Application for a non-material amendment following a grant of planning permission.
Town and Country Planning Act 1990

Single storey grand floor extensions, dormer extension, pitched roof to existing dormer.

AW/183/11/BR

AW/52/11

SOUTH ELEVATION (FRONT OF HOUSE)

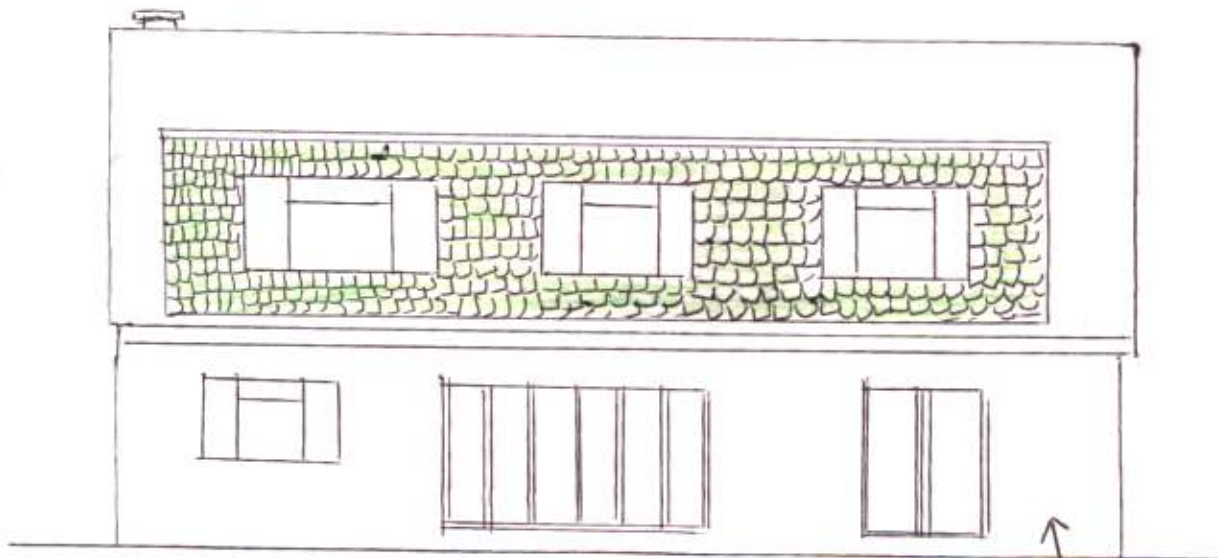
Front of house: To replace green hanging tiles with eternit cladding in off white/cream when pitching the dormer we had to remove some of the tiles and we discovered it was already clad underneath. Our builder advised as it would be the original cladding, we would like to replace all the green tiles on the front of the house with eternit which is a fibre cement weatherboard which seems very popular on this estate. We could then use the left over tiles to complete the rear dormer extension so the tiles would all match.

Rear extension: Yet to be started. We have taken in a sample brick to Builder Centre and we have been told the bricks actually colour with age (our bricks are a yellow colour now but they start off red). For this reason could we please render and paint white/(plain smooth finish) the single storey rear extension. We could then use the existing rear cream wall bricks for the front single storey extension and again all the bricks will match.
